Limerick City Greenway
(UL to NTP)

Stage 1 Road Safety Audit

Document Ref: P20100-PMCE-XX-XX-RP-SA-3_0002

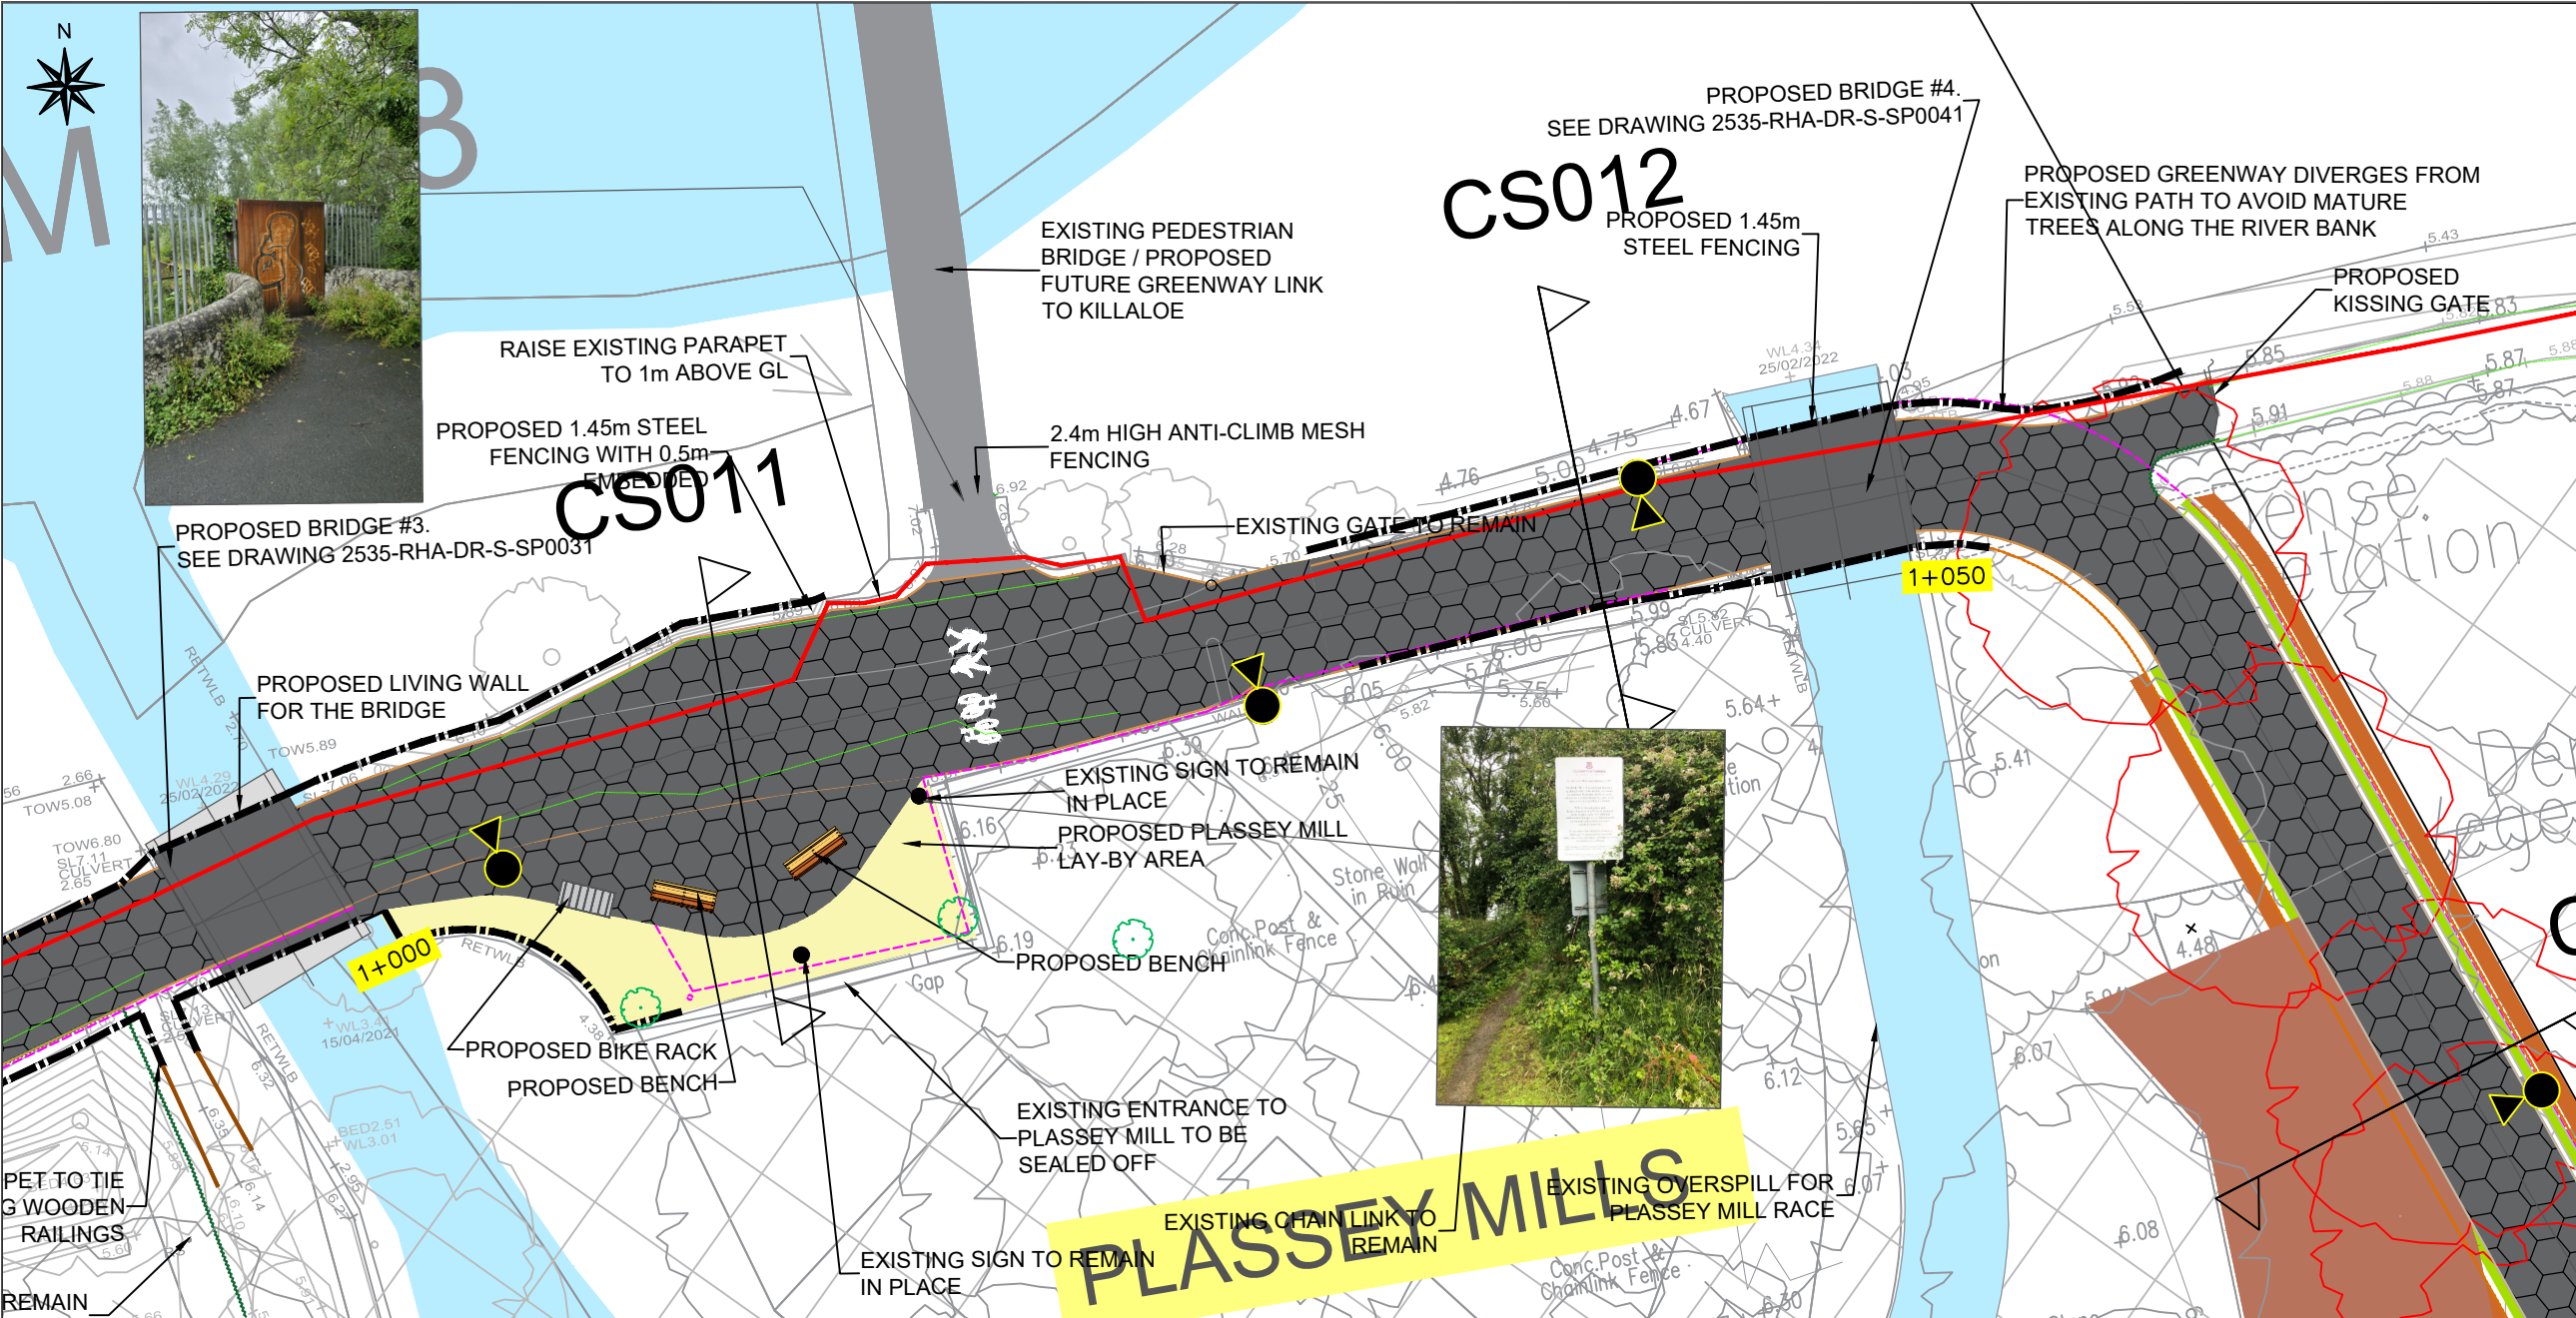
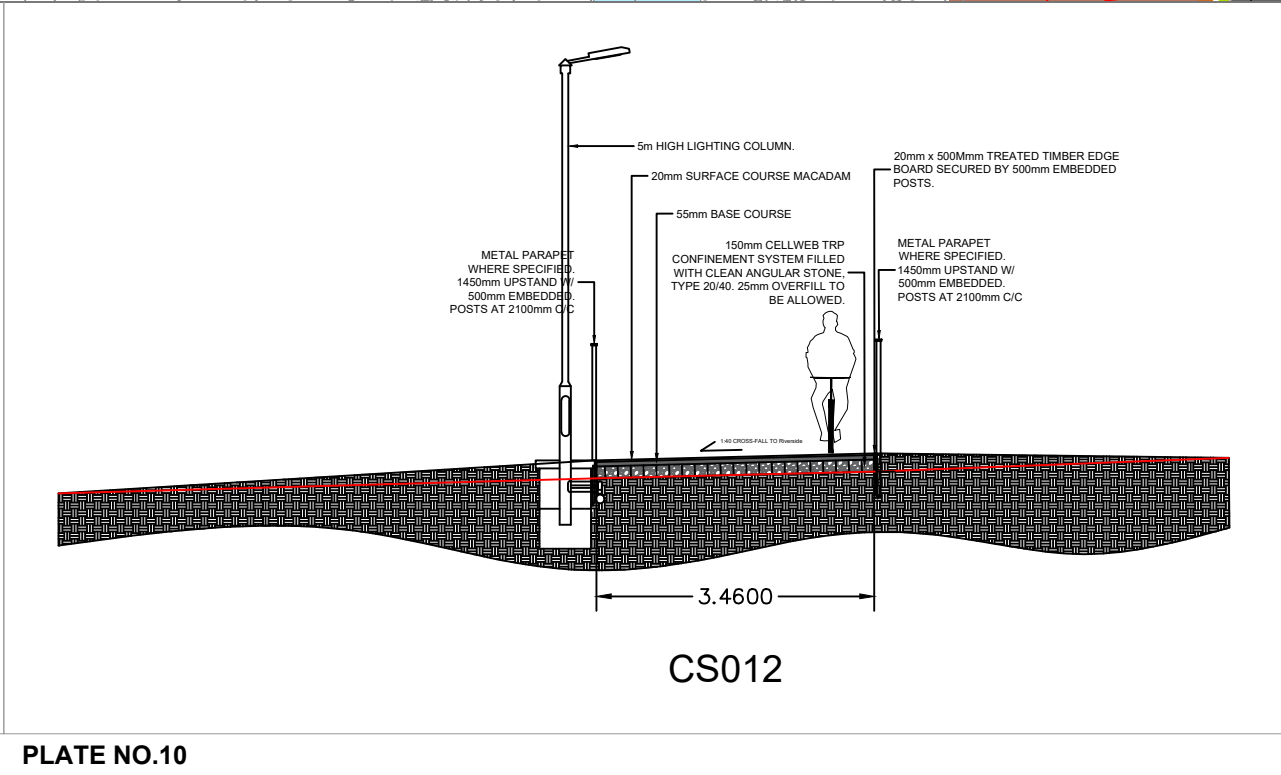
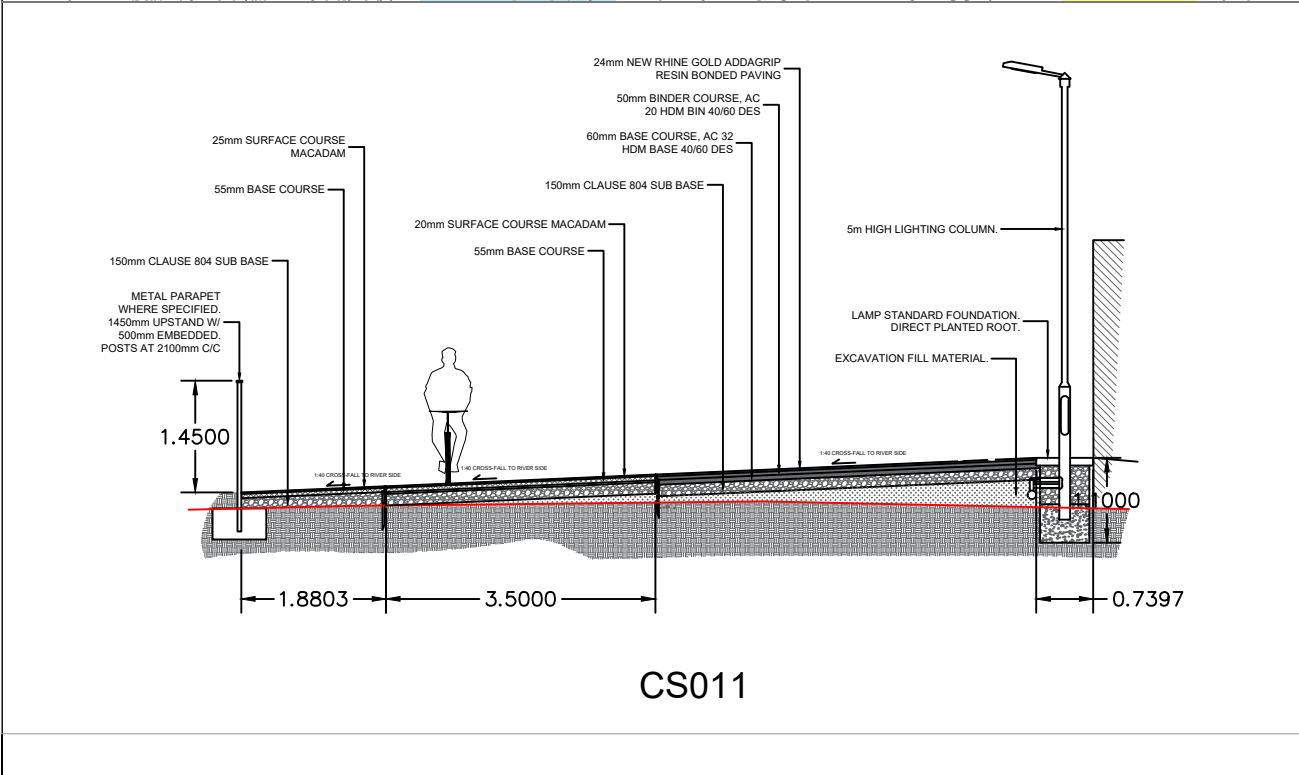
Location: Drawing No: 2535-RHA-XX-DR-C-PD0010 (Rev 2.0)

Summary: Informal cycle parking at lay-by areas may increase the risk of trips and falls.

Cyclists on the greenway may wish to stop at lay-bys to use the benches provided. The absence of cycle parking may lead to informal parking, where bicycles are left on the greenway, or beside the benches. This may increase the risk of trips and falls, leading to personal injury.

Cycle stands should be provided near lay-bys, and located strategically at areas where cyclists may wish to stop for short periods of time.
